Project No. 21071

**Re: SUB22-002 (Design Built Homes Preliminary Short Subdivision)  
Request for Information #2  
4719 86th Ave SE**

DRAWING: C1  
 SHEET: 1 OF 4

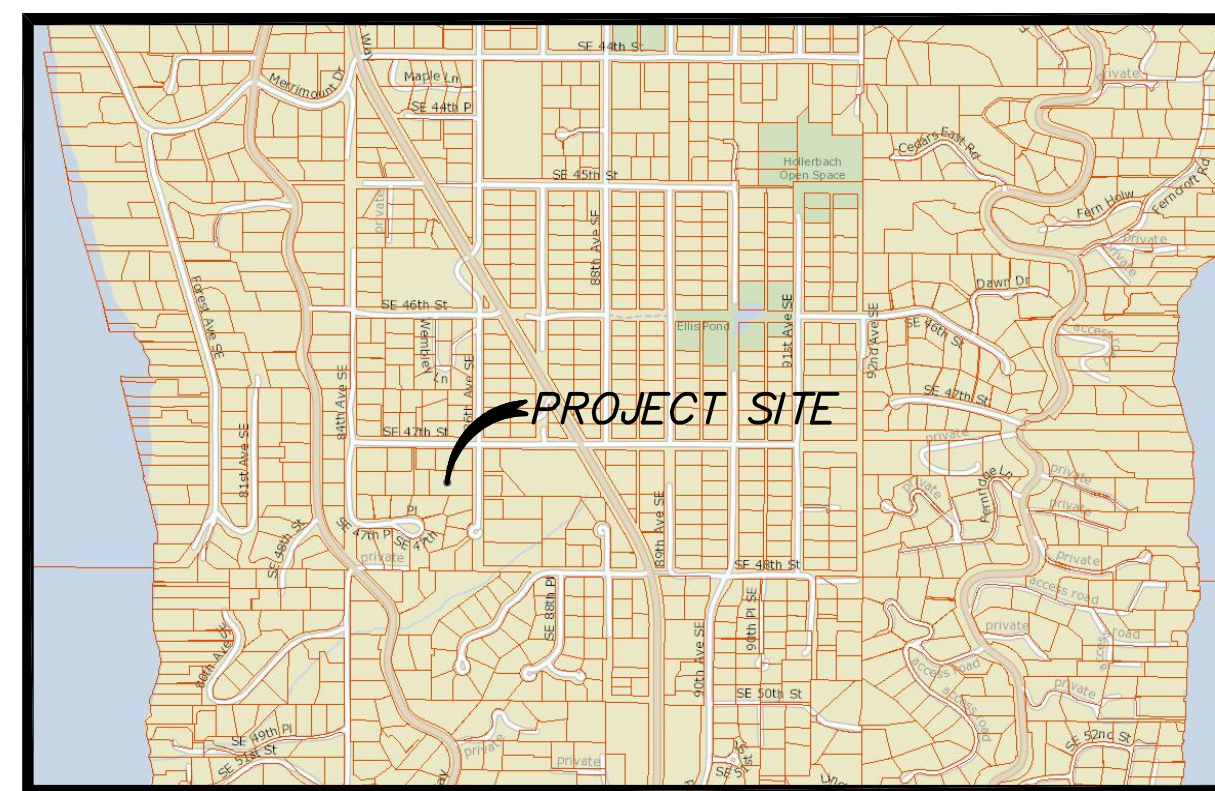
7. Please add the following note to the plan set: %All building permits are subject to meeting current fire code requirements at the time of a complete submittal, including fire apparatus access as outlined in adopted code sections of the International Fire Code Appendix D. Fire plan reviews will be conducted at the time of building permit submittal and may require additional fire protection systems and/or additional fire prevention measures for building approval.+

***Note added to Sheet C1***

SITE PLAN

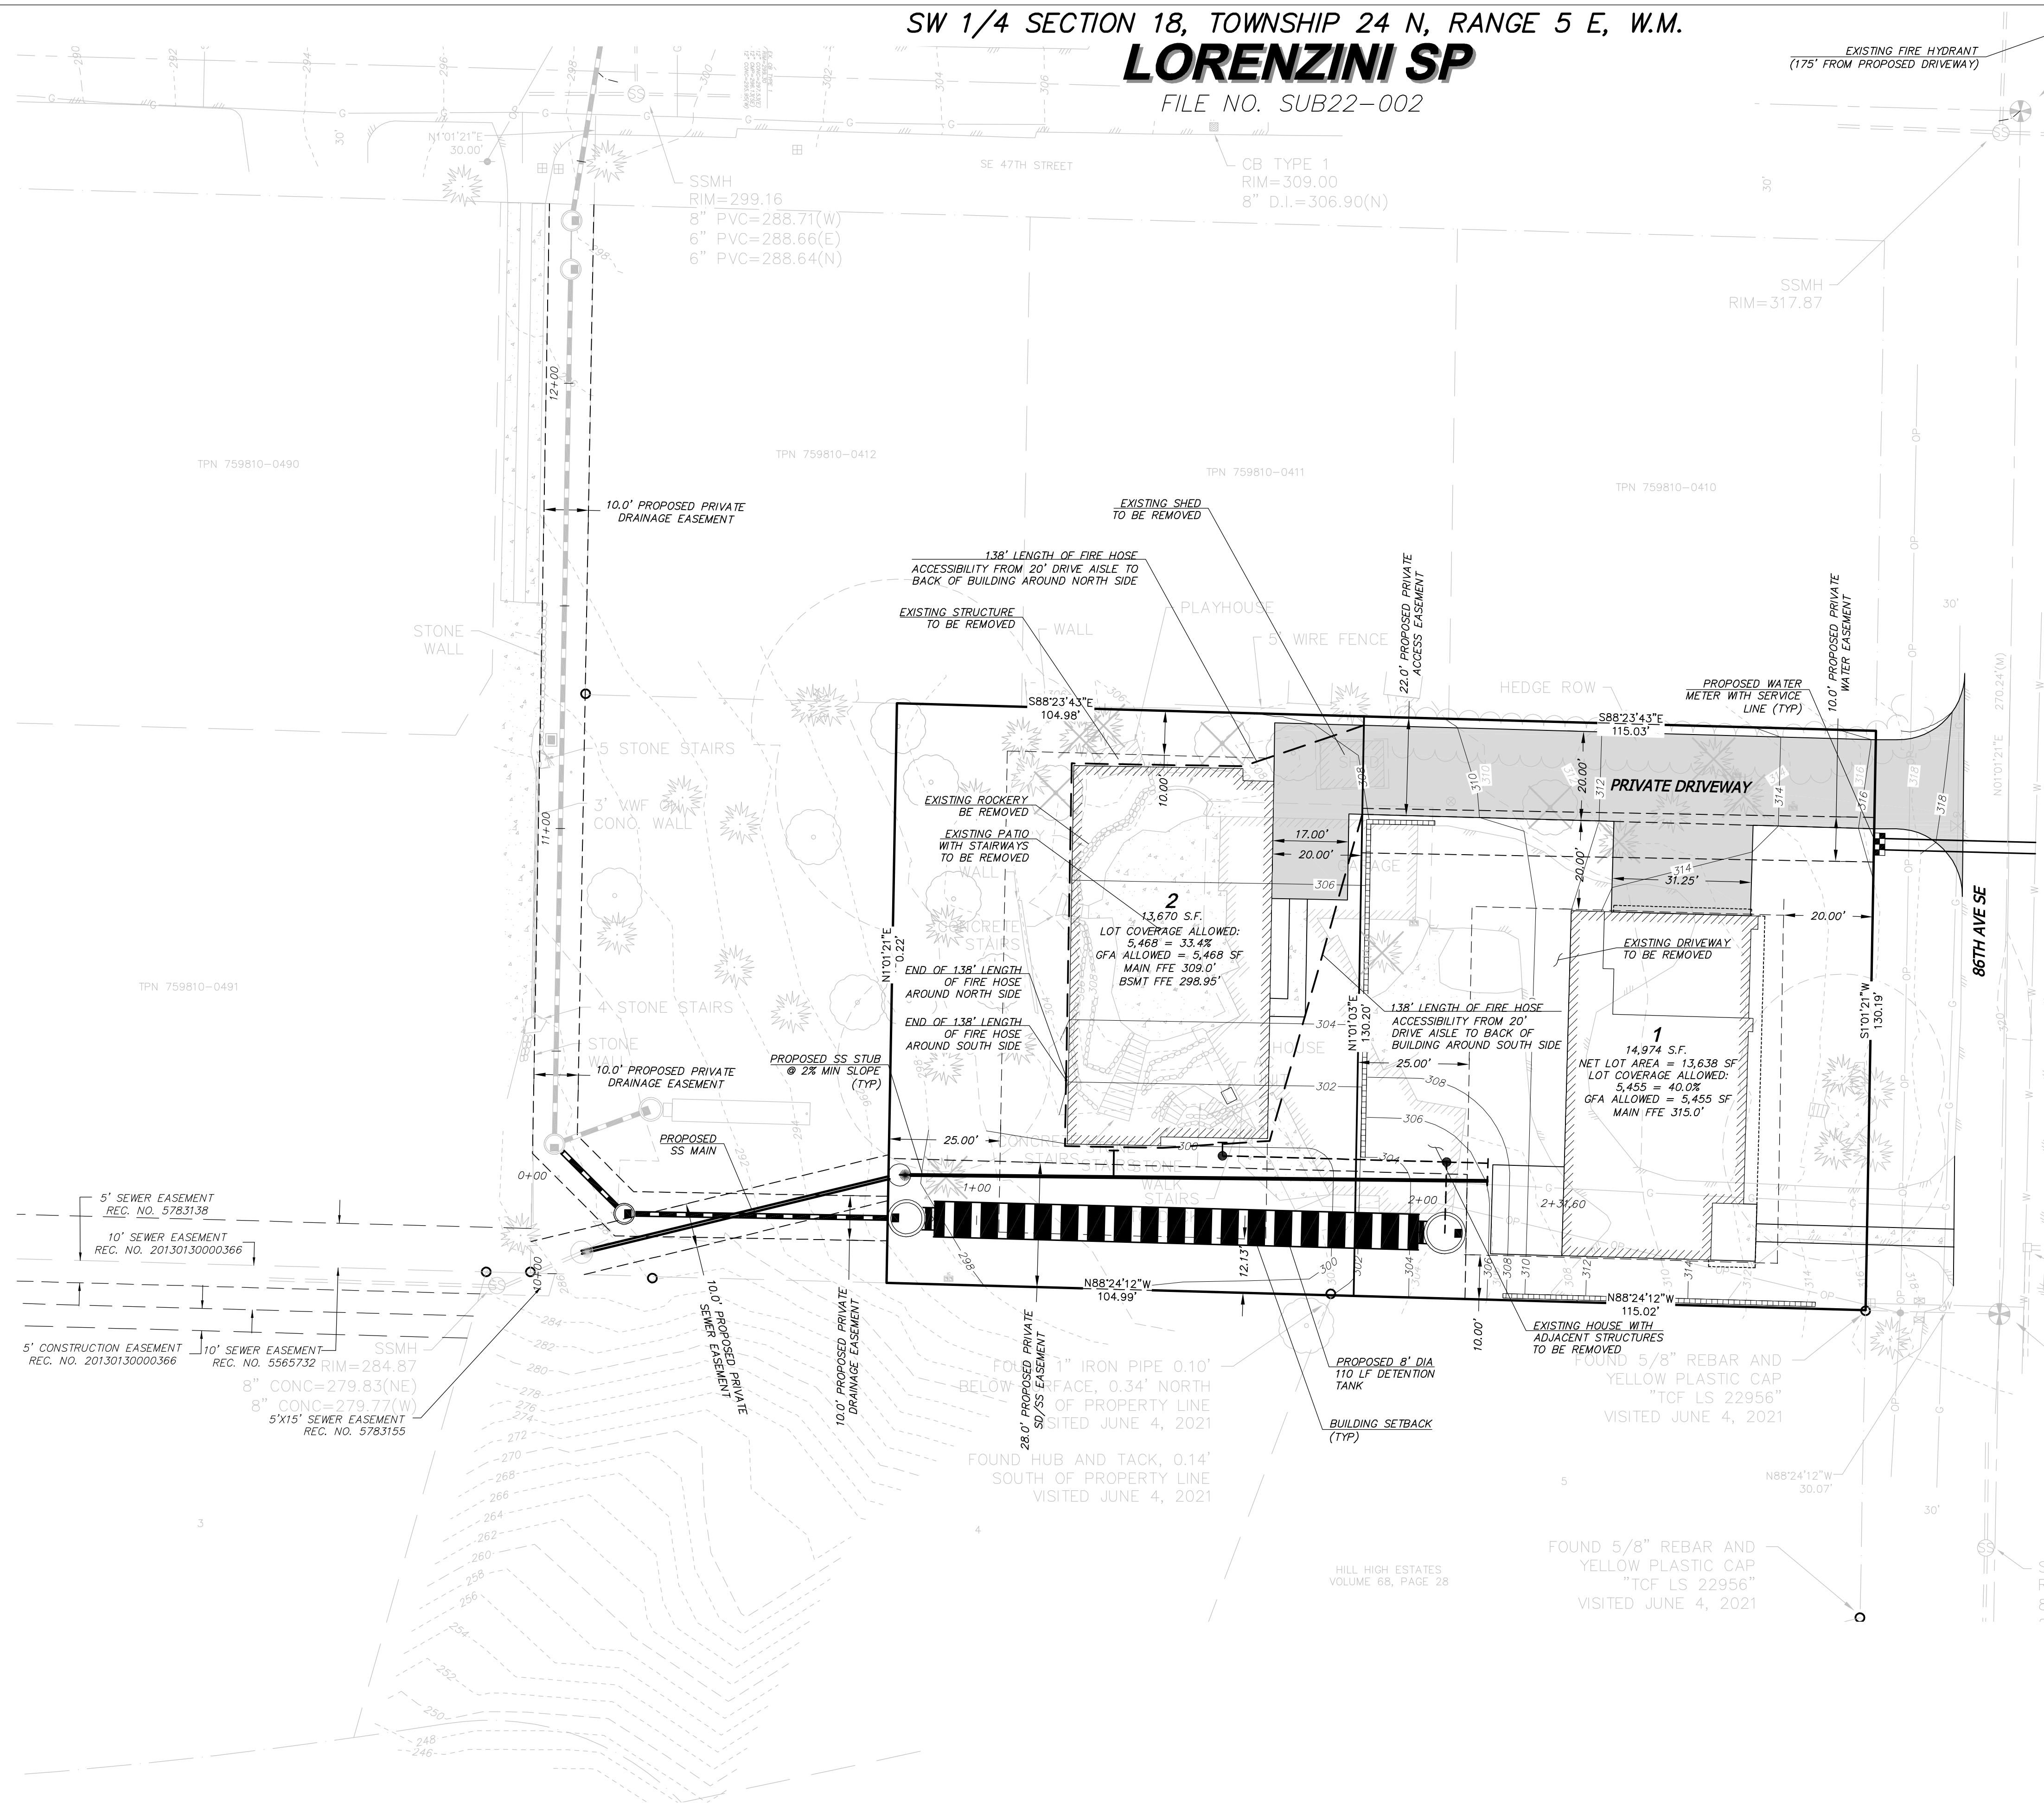
1. The lot dimensions shown on the provided site plan are not correct (see the table below). Please revisit the lot dimensions on the site plan to ensure that they are correct.

***Lot dimensions have been corrected.***

6. The driveway width must be increased to 20 feet all the way from Lot 1 to Lot 2 to meet current fire core requirements (Fire Access Road required within 150 feet of the furthest point of the residence as one would walk). The Fire Access Road requires a recorded easement to allow for future development. The construction of the roadway is not required until building permit submittal.

***The driveway width has been increased to 20 feet to the eastern property line of Lot 2.***

TREE PLAN

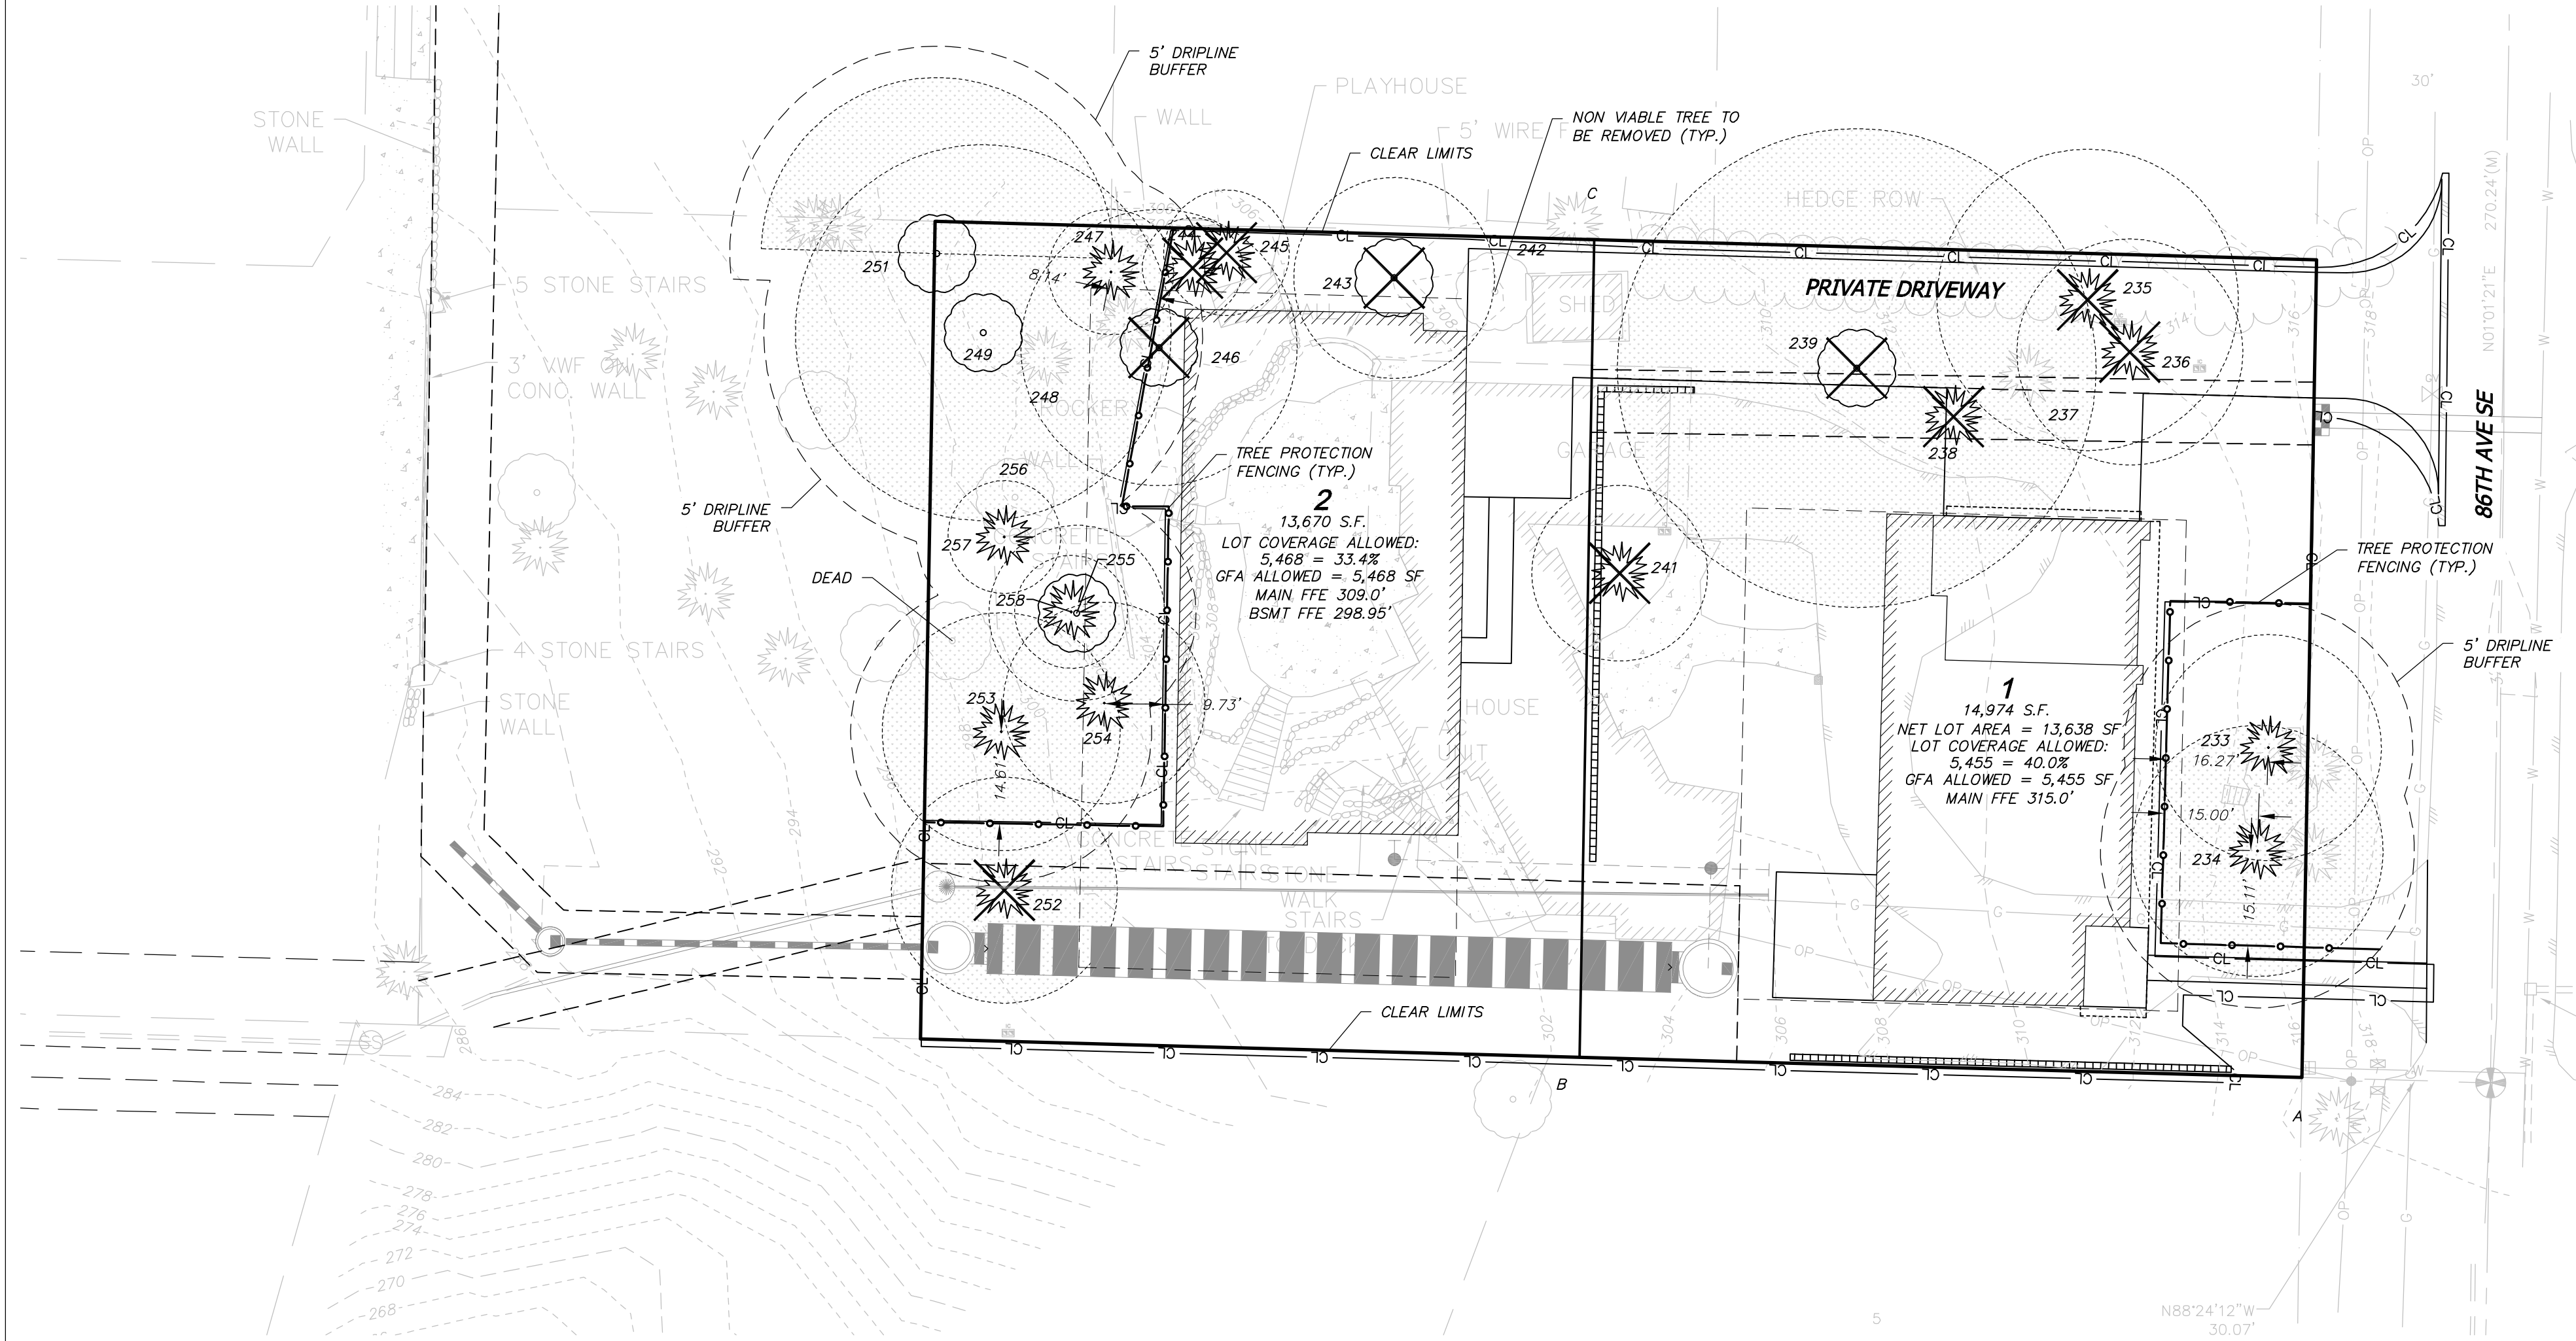
8. Please move the building pad and over excavation outside of the critical root zones of trees 233, 234, 249, and 253. Air excavation root analysis will need to be provided prior to construction to demonstrate that these trees will not be damaged by the proposed work. The analysis will need to call out the specifics of the project design. Alternatively, these trees could be proposed to be removed if the minimum required number of regulated trees will be retained.

**See revised arborist report for response to this comment.**
